Norfolk Boreas Offshore Wind Farm

Statement of Common Ground

Broadland District Council

Applicant: Norfolk Boreas Limited
Document Reference: ExA.SoCG-3.D10.V5
Deadline 10
Date May 2020
Revision: Version 5
Author: Royal HaskoningDHV

www.createconsultingengineers.co.uk

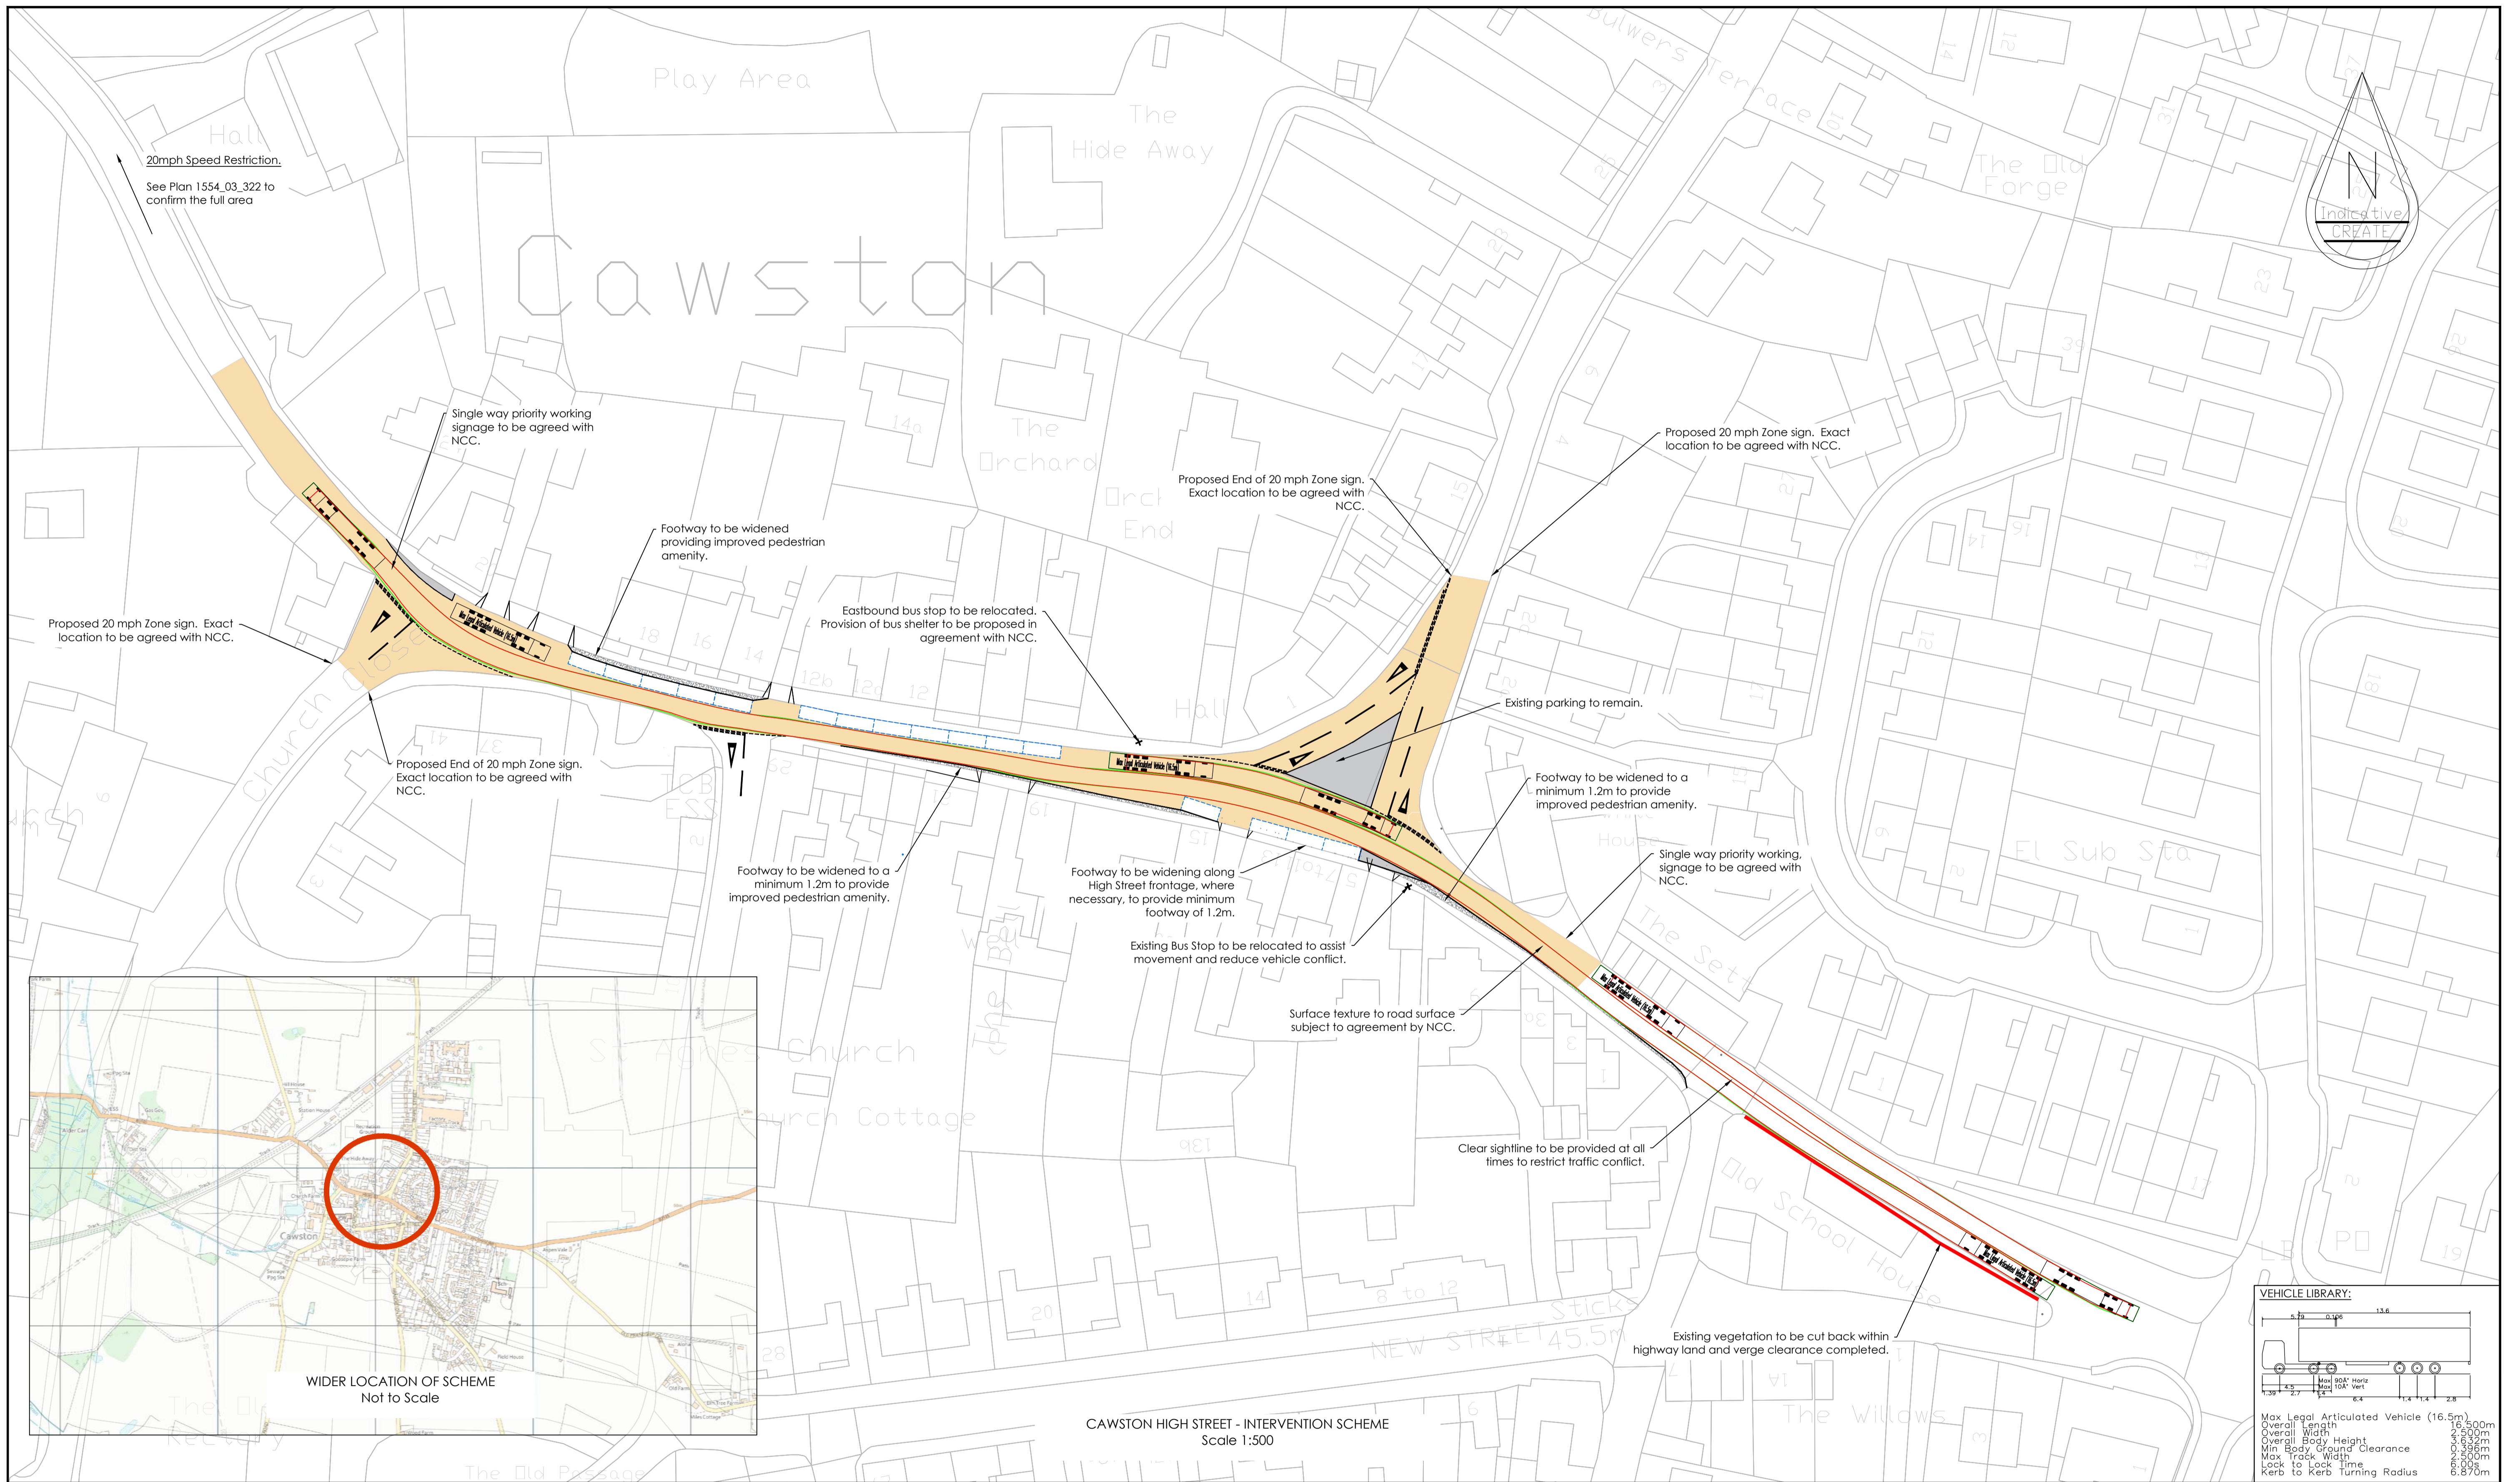
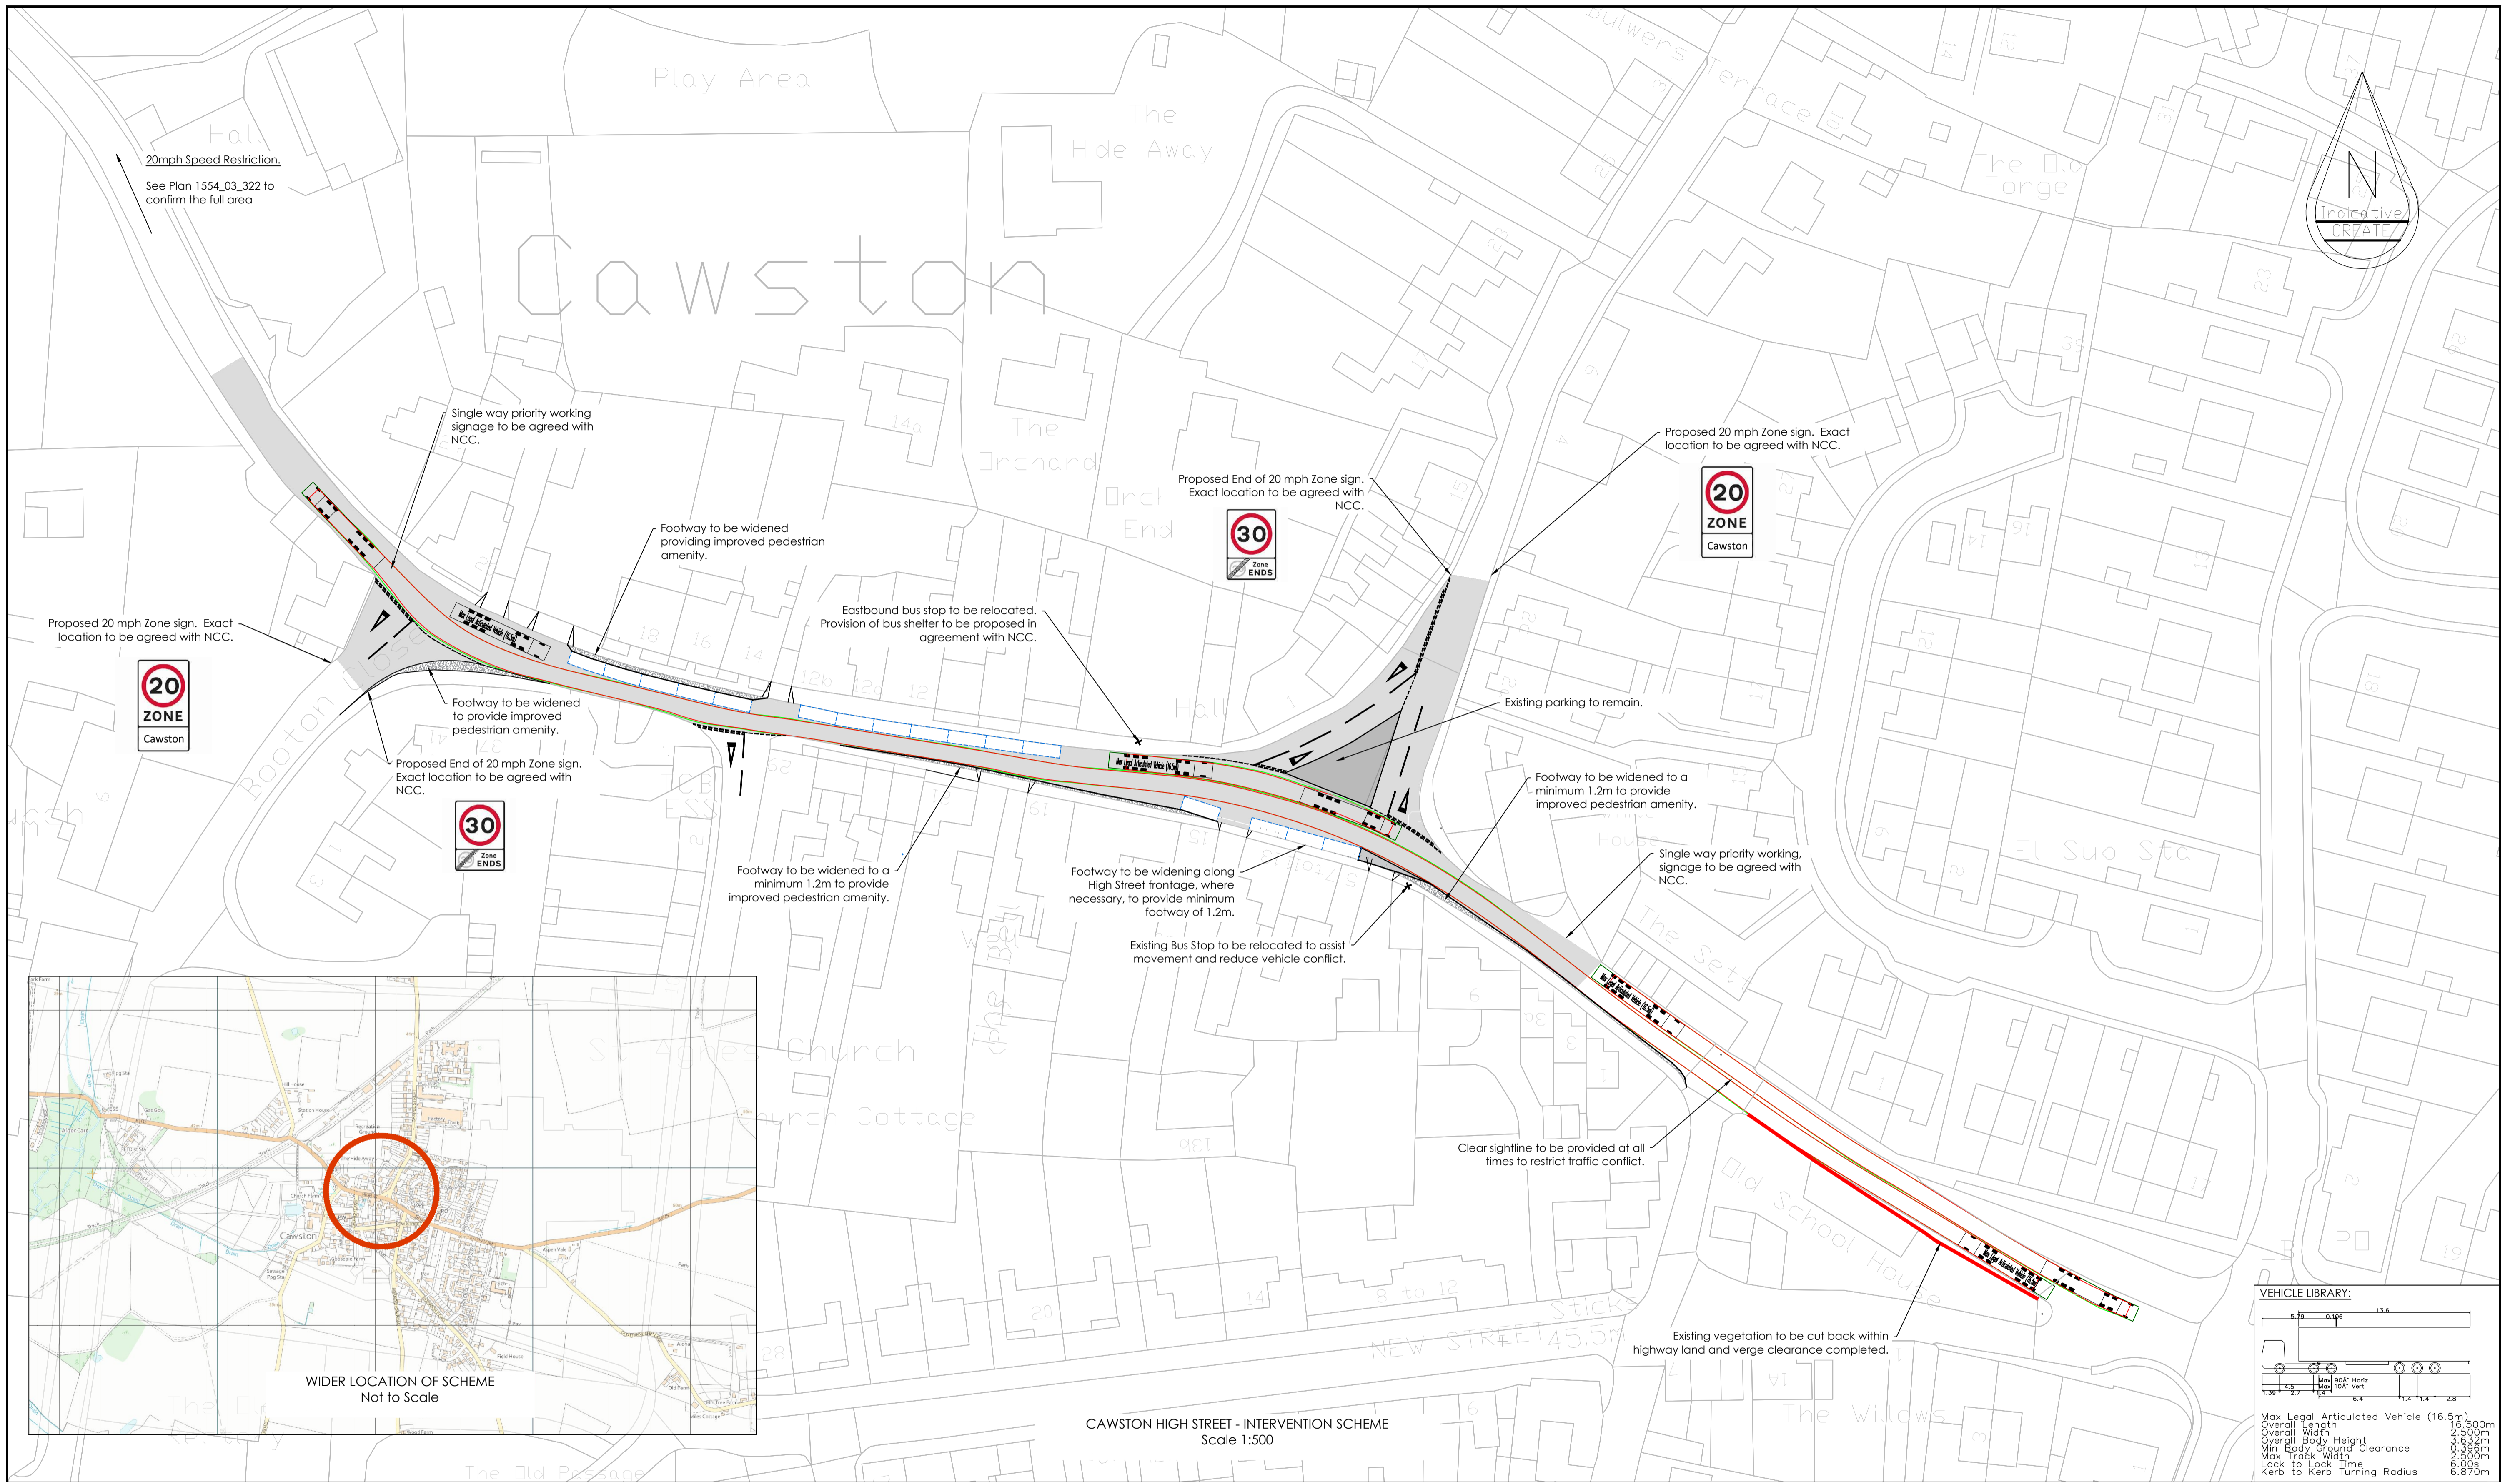
Topic	Norfolk Boreas Limited position	Broadland District Council position	Final position
	<p>findings are considered robust and with the inclusion of the identified mitigation measures, impacts have been reduced to non- significant.</p>		
	<p>B1145, Cawston An assessment of cumulative noise, vibration and air quality impacts associated with Norfolk Boreas and Hornsea Project Three along the B1145 through Cawston has been assessed (section 25.9 of ES Chapter 25 (APP-238) and section 26.8 of ES Chapter 26 (APP-239)). The assessment concluded that residual impacts related to noise, vibration and air quality are not significant.</p> <p>The traffic cap identified within the Application set out that cumulative HGV traffic must not exceed 260 daily HGV movements through Cawston, by reducing the Norfolk Boreas daily HGV movements to 133 (combined with the Hornsea Project Three peak of 127 daily HGV movements). However, the Applicant has sought to further optimise the construction programme to reduce the Norfolk Boreas Scenario peak traffic as low as practicable. As such, the Applicant is able to commit to a Norfolk Boreas peak of 112 (reduced from 133) daily HGV movements (in both the single project and cumulative scenario).</p> <p>These reductions do not change the findings of the CIA (the residual impacts remains minor adverse for noise impacts) but recognise the concerns of Cawston Parish Council and Broadland District Council and represent an effort to reduce these short-term peaks in construction traffic to as low as</p>	<p>The District Council recognise that the applicant has committed to further reduce the peak traffic levels in Cawston to Norfolk Boreas peak of 112 (reduced from 133) daily HGV movements (in both the single and cumulative scenario)</p> <p>BDC appreciate confirmation that the Traffic Management Plan will need to be agreed with BDC.</p> <p>In respect of the findings of the Clarification Note on the potential noise, vibration and air quality effects of the Cawston HIS.</p> <p>In terms of the noise effects it is considered that the basic noise level calculation assumes a speed of 20mph in free flowing traffic, in free-field conditions, with no account taken of the distance between source and receptor, nor façade or reflection effects. It is also not clear from the report whether the applicant has applied the CRTN</p>	<p>The assessment for cumulative impacts through Cawston for air quality and vibration are agreed by both parties however BDC still have concerns regarding potential impacts of traffic noise.</p>

Topic	Norfolk Boreas Limited position	Broadland District Council position	Final position
	<p>practicable. This further commitment is captured in the Outline Traffic Management Plan.</p> <p>With the assessments of potential cumulative noise, vibration and air quality impacts along the B1145 through Cawston and the further commitment to reduce Norfolk Boreas peak daily HGV movements to 112, the assessments findings are considered robust, and with the inclusion of the identified mitigation measures, impacts have been reduced to non- significant.</p> <p>Mitigation is proposed for Link 34 (B1145), including the development of a Highways Intervention Scheme and is captured within section 4.3.1 of the Outline Traffic Management Plan (OTMP) (document reference 8.8, Version 4) and secured through DCO Requirement 21. Mitigation includes a cap on the maximum number of daily HGV movements, temporary speed restrictions, resurfacing the road, incorporation of formalised parking and parking restriction, and priority warning signs. Also includes prohibition of HGV deliveries during term time school pick up and drop off times (7:30am – 9:00am and 3:00pm – 4:00pm, Monday to Friday) and from 6pm to 9am (in line with parking restrictions).</p> <p>Norfolk County Council have indicated (during a meeting held on the 16th March 2020) that no further amendments were required to the HIS and there were no remaining technical objections. Following agreement on the HIS the Applicant has produced a Clarification Note [REP8-028],</p>	<p>definition of HGV’s i.e. all vehicles with an unladen weight of 1525kg and above. Furthermore the HIS requires all vehicles to brake, stop, idle and accelerate on multiple occasions along the High Street. It is therefore considered that it does not describe the actual noise levels that will be experienced by residents and pedestrians in the centre of Cawston, which will possibly be 4dBA higher when taking the façade and reflective effects as well as the closeness of dwellings to the road into account.</p> <p>In terms of the vibration effects it is considered that these are acceptable based on the results of the H3 monitoring. It is suggested that the applicant undertakes its own measurement surveys prior to the commencement and approval of the construction traffic management plan.</p> <p>In terms of the air quality effects it is considered to be acceptable.</p>

Topic	Norfolk Boreas Limited position	Broadland District Council position	Final position
	<p>submitted at Deadline 8, which provides further information on the potential noise, vibration and air quality effects of the HIS which would serve to reduce traffic impacts through Cawston (Link 34, B1145).</p> <p>The findings of the road traffic noise assessment concluded that for Norfolk Boreas alone and cumulatively with HP3 impacts will be no greater than minor adverse, and therefore will have no significant effect upon the receptors in the vicinity of Link 34.</p> <p>The vibration assessment concluded that the predicted vibration impacts on humans are currently below the threshold level “Less than Low probability of adverse comment”. The predicted vibration impacts on human receptors as a consequence of implementing the HIS are minor adverse, which is not significant in EIA terms. Predicted vibration impacts on buildings (including those designated as listed buildings) are below the threshold level for cosmetic damage at each of the four receptor locations (representative of listed and residential dwellings along link 34). Although it is noted the frequency of vibrational transfer events from HGV movements along Link 34 to each building during the scheme mobilisation hours will increase, the predicted impacts are minor adverse, which is not significant in EIA terms.</p> <p>The air quality assessment concluded that the pollutant concentrations were well below the respective annual mean air quality Objectives (40µg.m-3 for NO2 and PM10,</p>

Topic	Norfolk Boreas Limited position	Broadland District Council position	Final position
	<p>25µg.m-3 for PM2.5) at all receptors identified. Therefore, impacts were assessed as not significant</p> <p>This combined suite of measures for Link 34 will serve to mitigate the effects of either Norfolk Boreas or Hornsea Three alone or both projects together. Whichever project progresses to construction first will introduce the measures and the final project will remove the mitigation at the end of construction. The scheme will be implemented under both scenarios, under Scenario 1 Norfolk Boreas will retain or reinstate the scheme from Norfolk Vanguard.</p> <p>In accordance with DCO Requirement 21 the final Traffic Management Plan will be approved the relevant planning authority.</p>		
	<p>The assessment of impacts of both scenarios for construction, operation and decommissioning presented in section 25.8 of ES Chapter 25 (APP-238) and section 26.7 of ES Chapter 26 (APP-239) is appropriate and, assuming the inclusion of the mitigation described, impacts from noise, vibration and air quality are non-significant in EIA terms.</p>	<p>Agreed</p>	<p>It is agreed by both parties that the assessment of impacts for construction, operation and decommissioning presented is appropriate</p>
